**Subject: Request for Modification to the Section 404 Individual Permit and Section 401 Water Quality Certification for I-485 (Charlotte Outer Loop) from east of I-77 to I-85 in Mecklenburg County. Division 10, TIP's R-2248 E and R-2123 CE, Debit \$570 from WBS 34410.3.GV2**

**Reference: USACE Individual Permit Action ID SAW-2011-01237, dated Nov.22, 2011.  
NCDWQ Water Quality Certification No. 003868, dated October 14, 2011.**

**R-2248 E – Roadway Portion of Future I-485 between I-85 and NC 115**

Permit Drawing  
Sheet 19 of 108

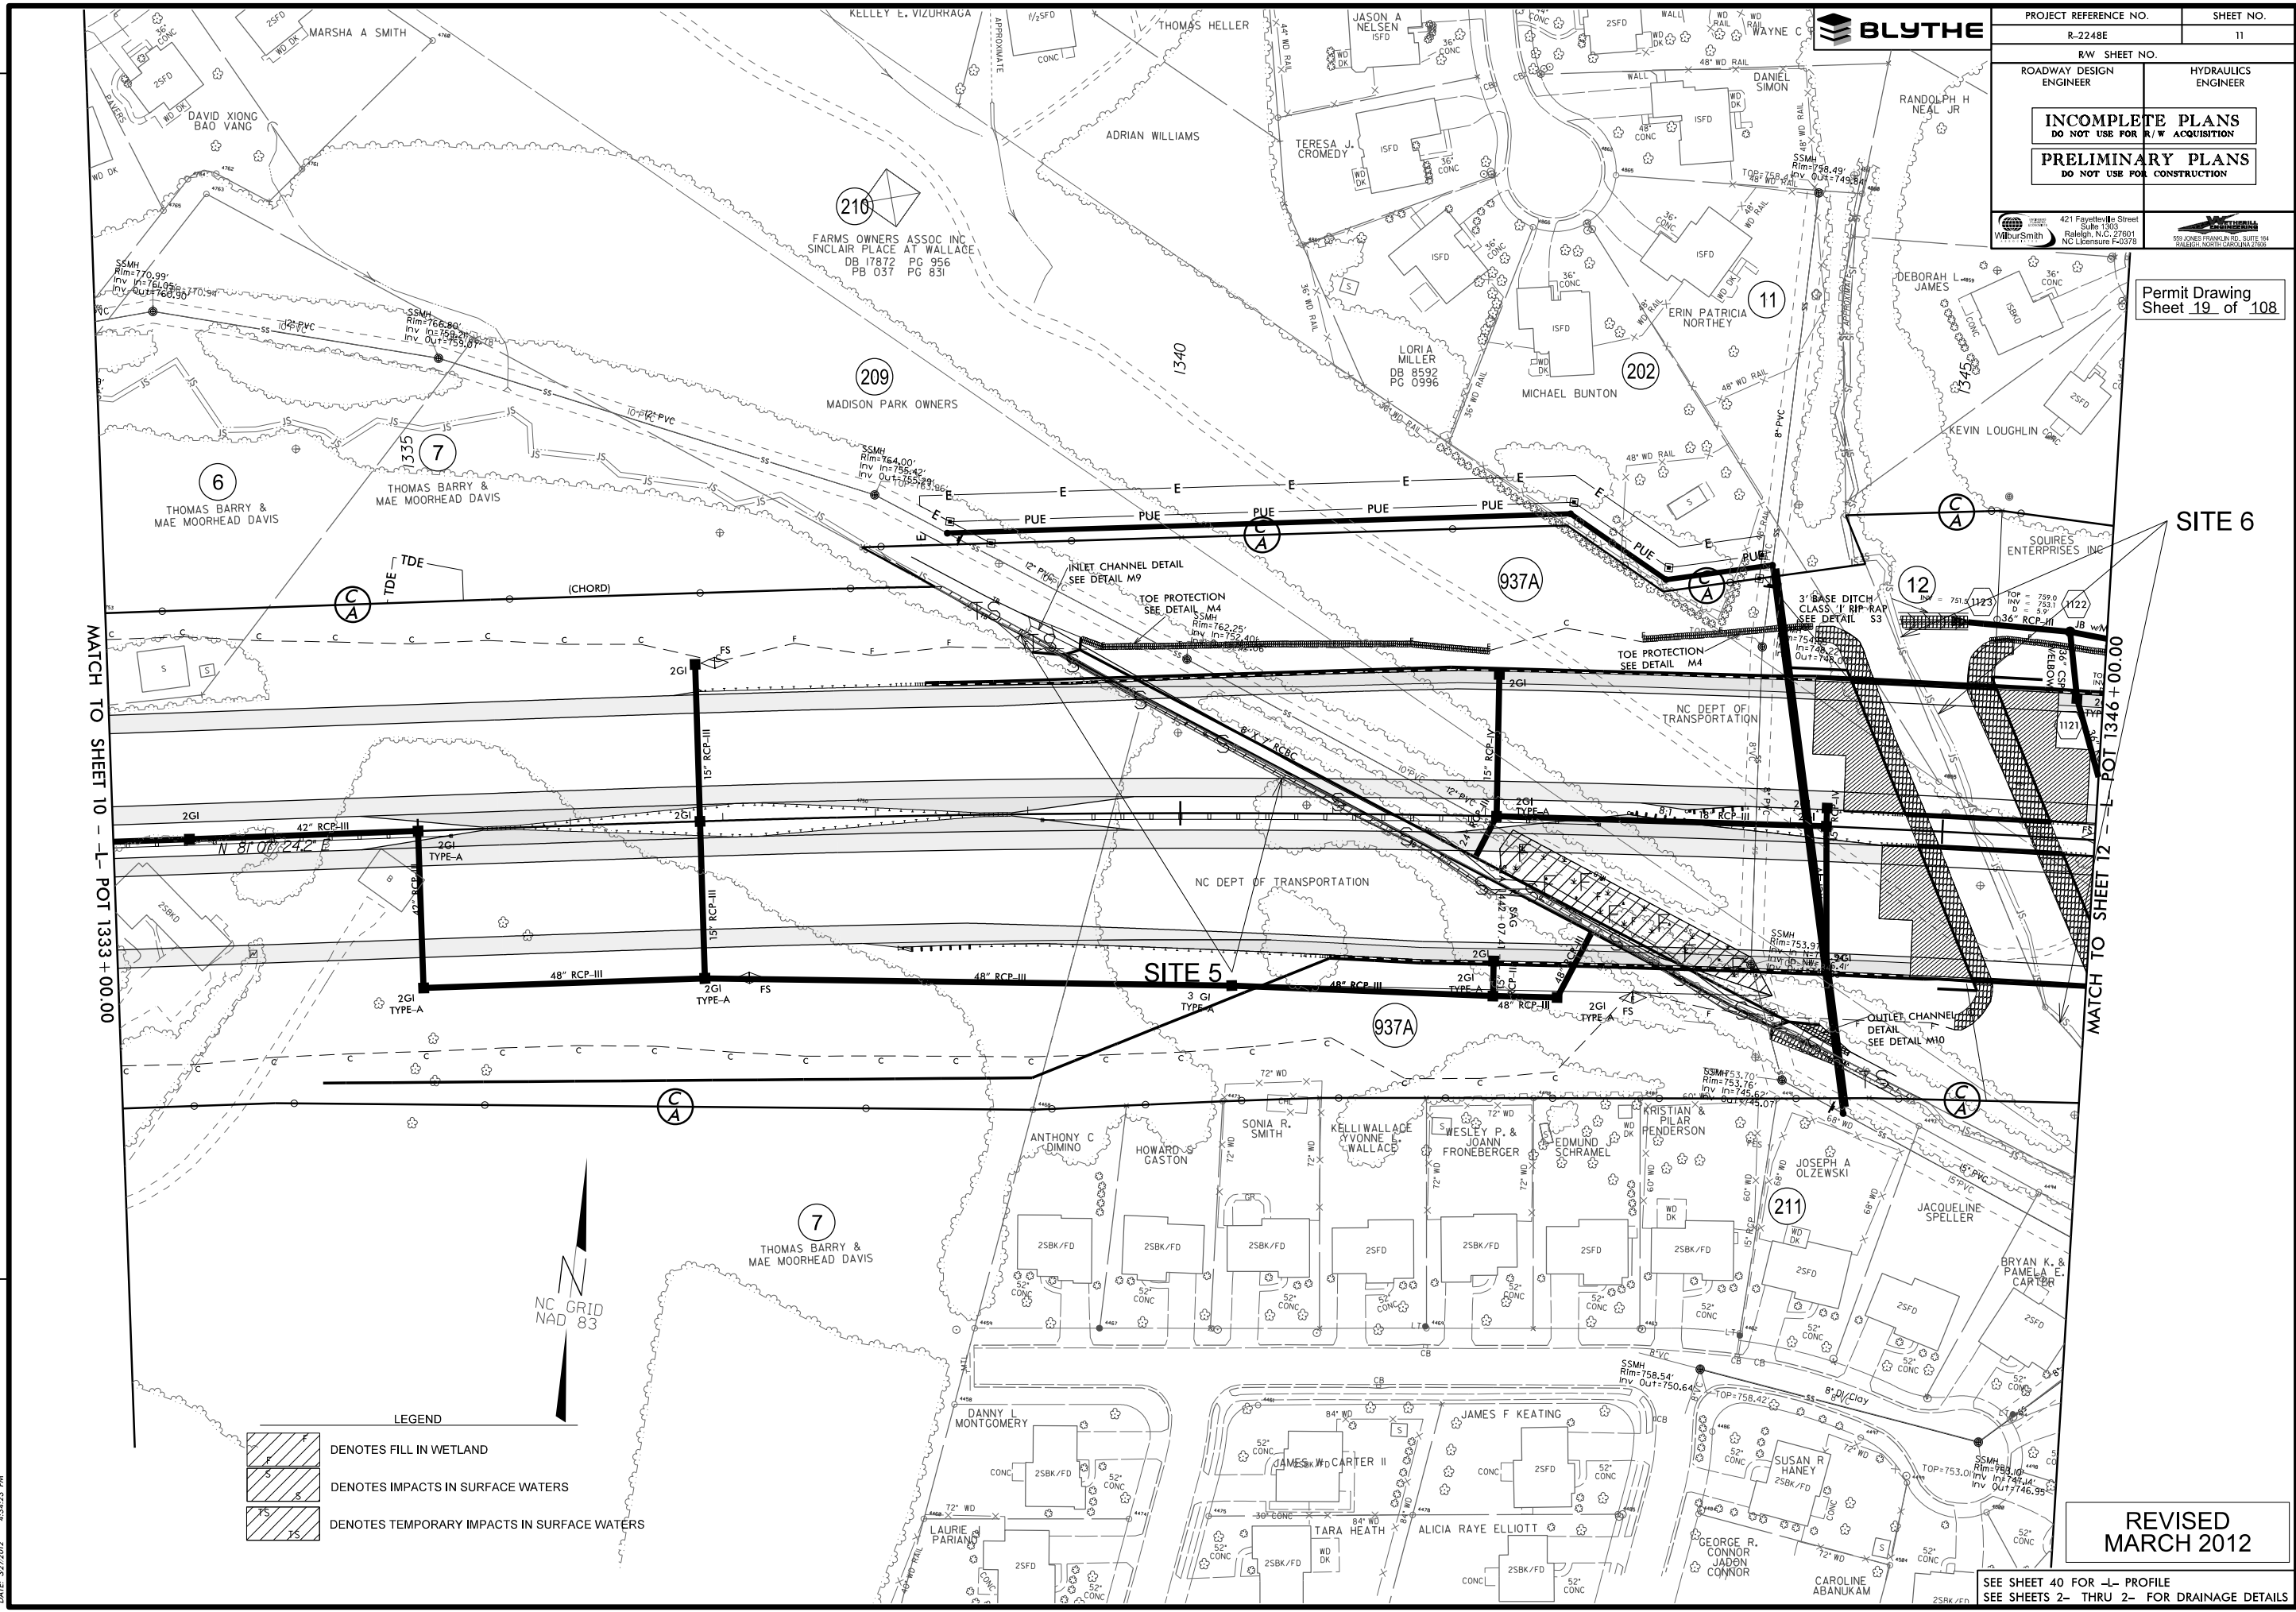
**Revision:** Length of 8' x 7' RCBC increased from 489 to 525 linear feet. (+36 feet)

**Reason:** The 8' x 7' RCBC was lengthened and slightly shifted to the south. Minor grade, fill slope, and alignment changes were necessary to accommodate the approach to the new bridge over Stream S7.

**Impacts:** Permanent stream impacts associated with the 8' x 7' RCBC have increased by 36 linear feet, from 489 to 525 linear feet.  
Bank stabilization has decreased by 9 linear feet, from 56 feet to 44 feet.  
Temporary stream impacts have been decreased by 9 linear feet (but remain at 0.01 acre.)  
Wetland impacts at this site have not changed.

Permit Drawing  
Sheet 21 of 108

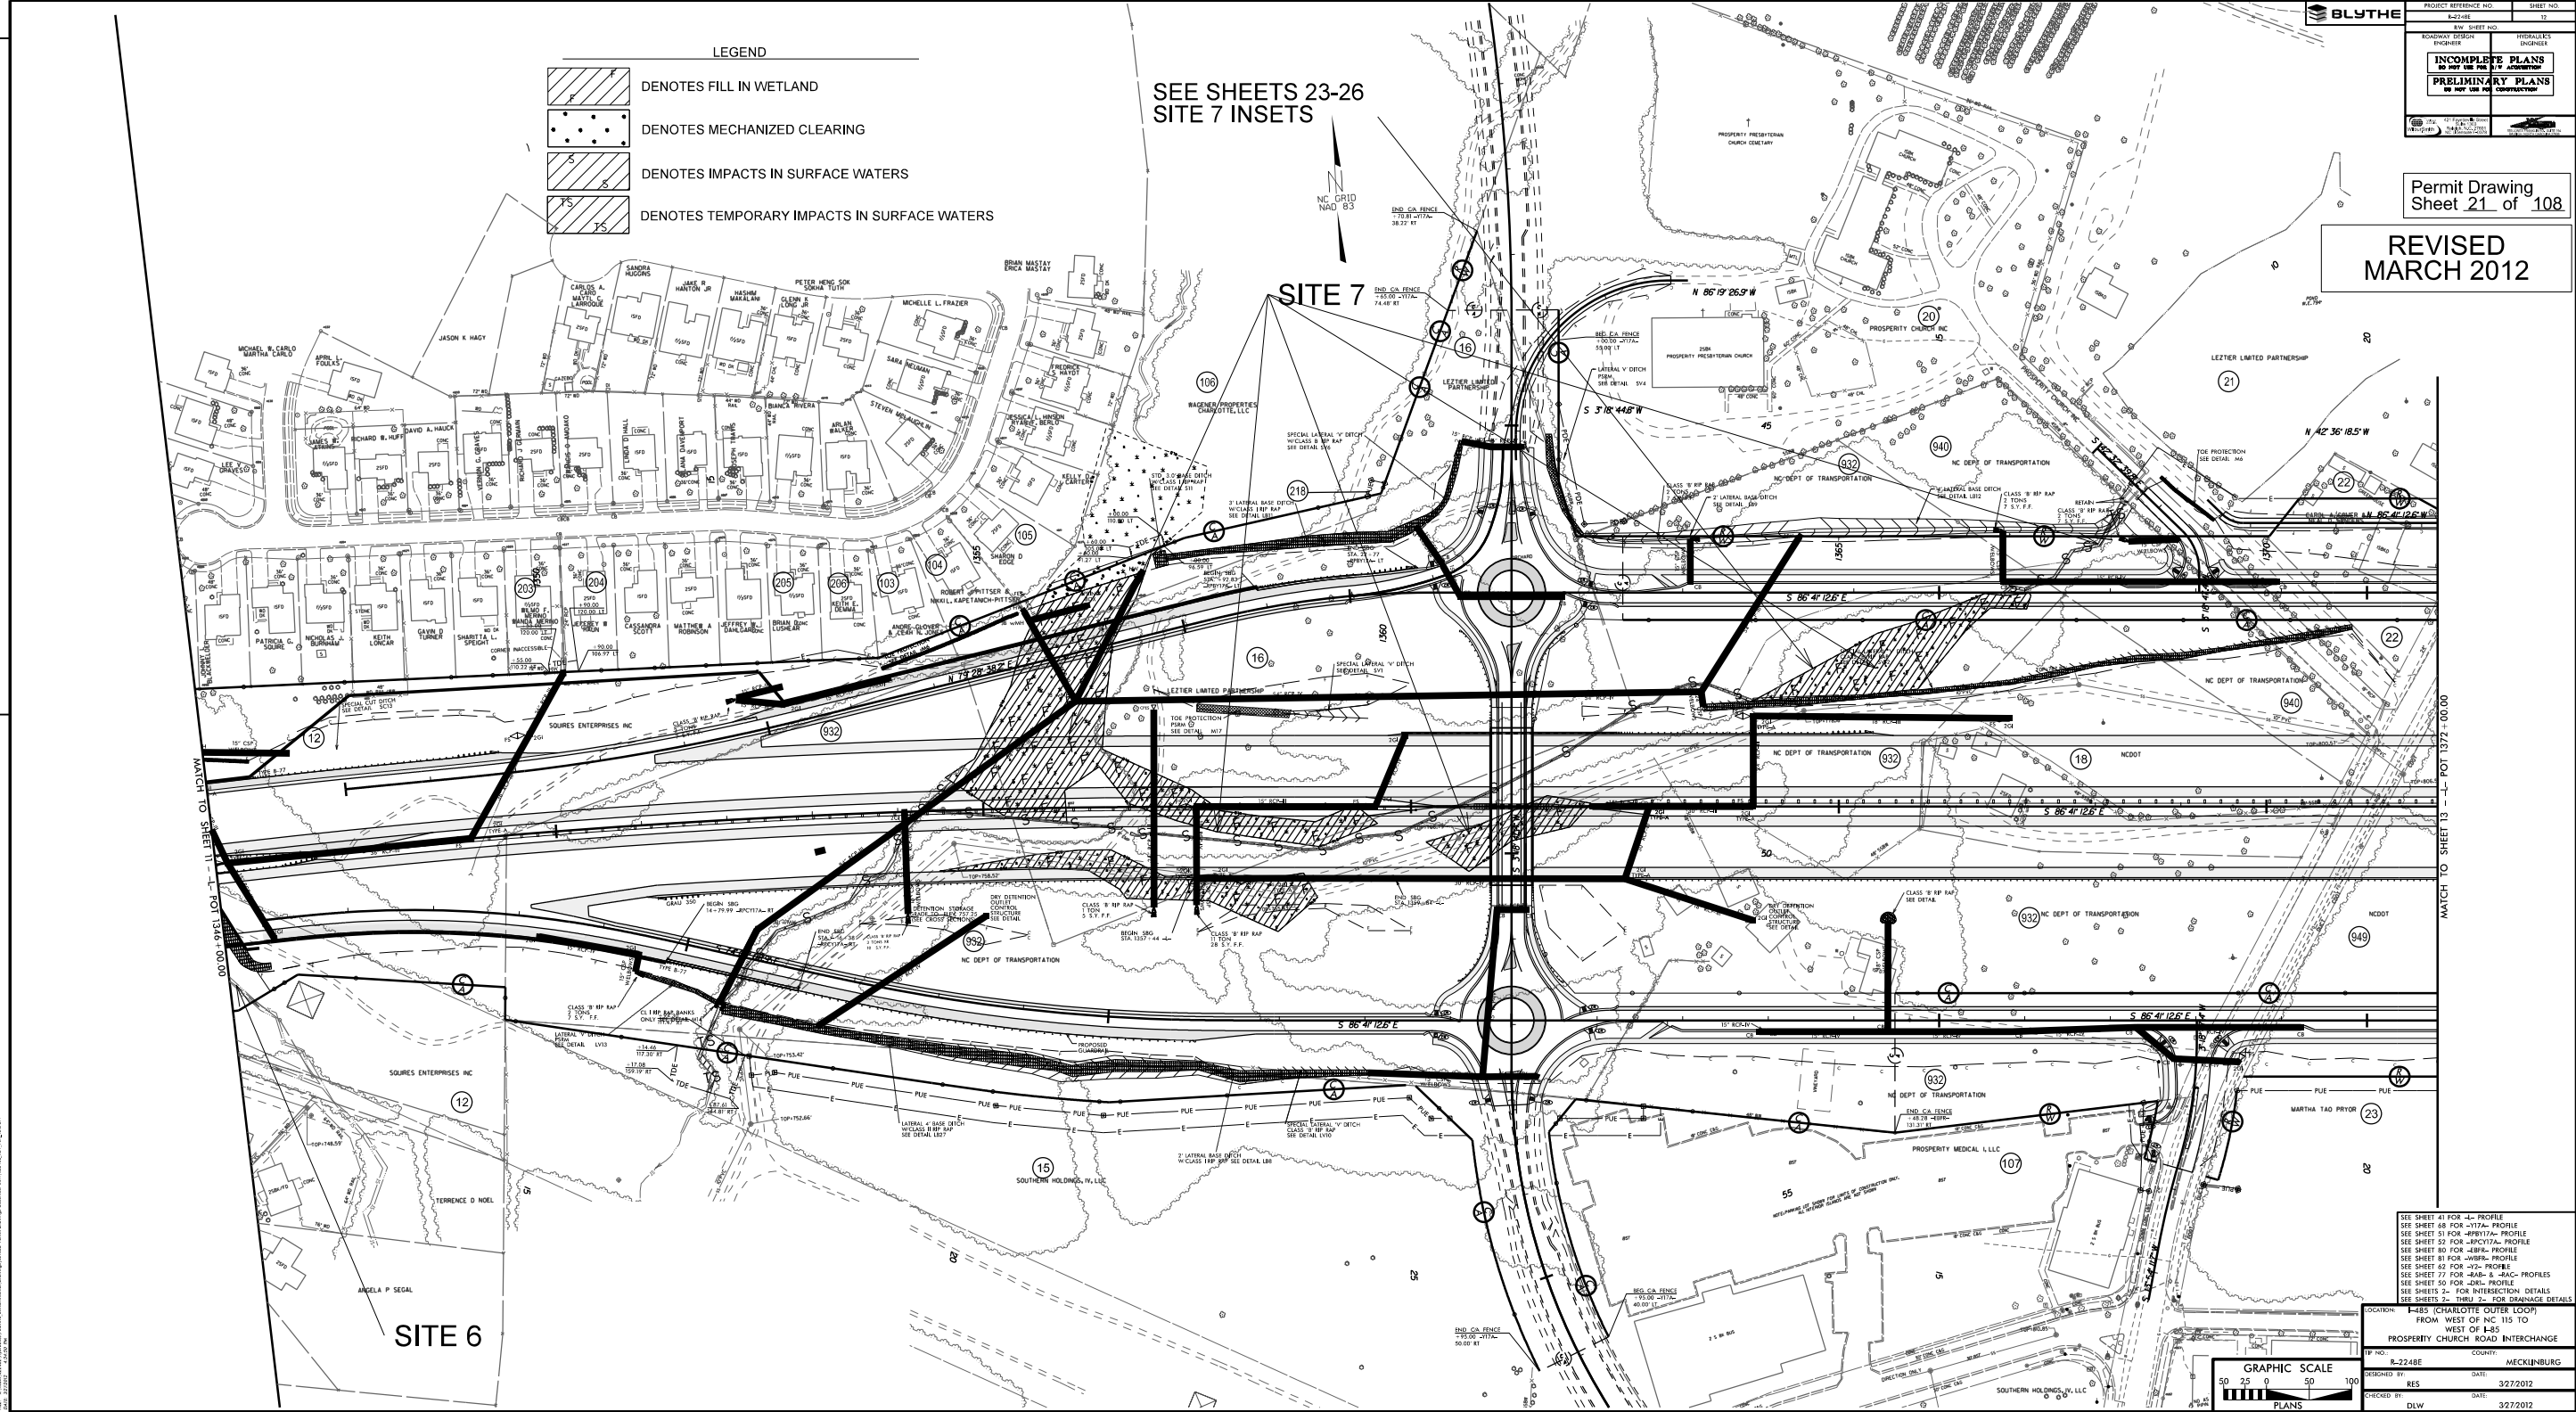
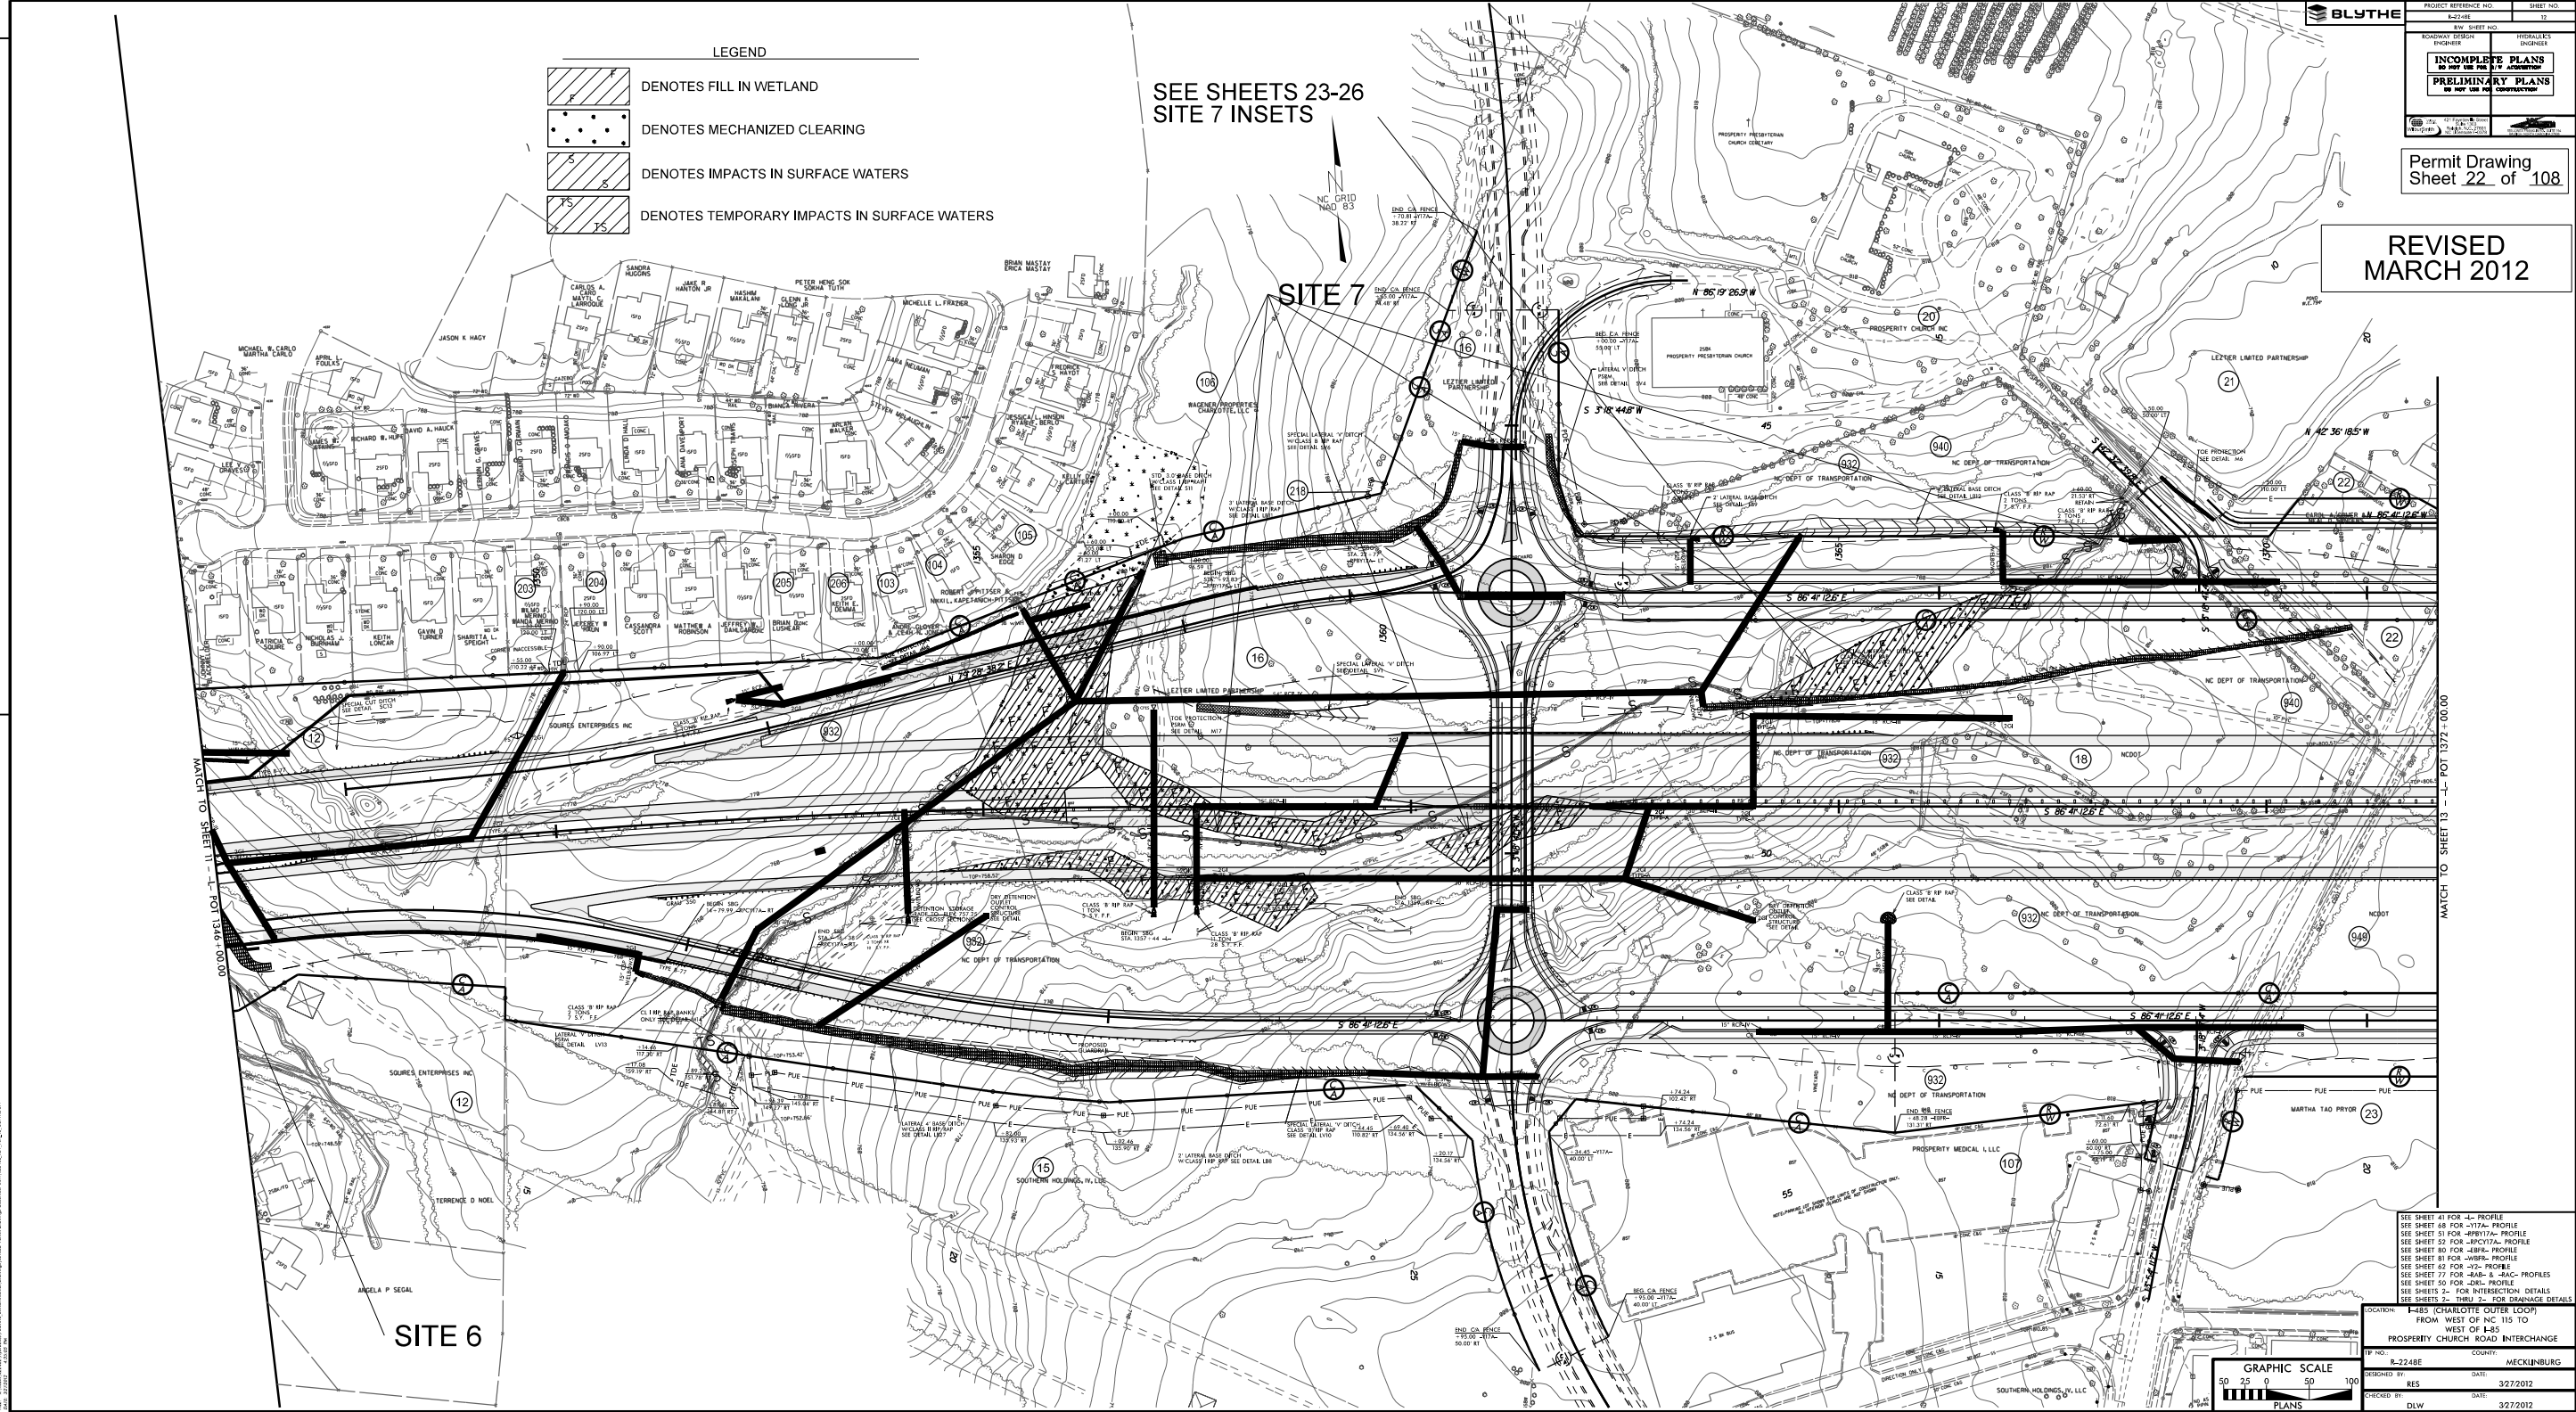
**Revision:** Elimination of 9' x 7' RCBC at Site 6.

**Reason:** Dual bridges will be constructed to cross the area including Stream S7.

**Impacts:** All stream impacts (276 of permanent stream impacts, and <0.01 acre of temporary stream impacts) and 36 feet of bank stabilization at Site 6 have been eliminated.
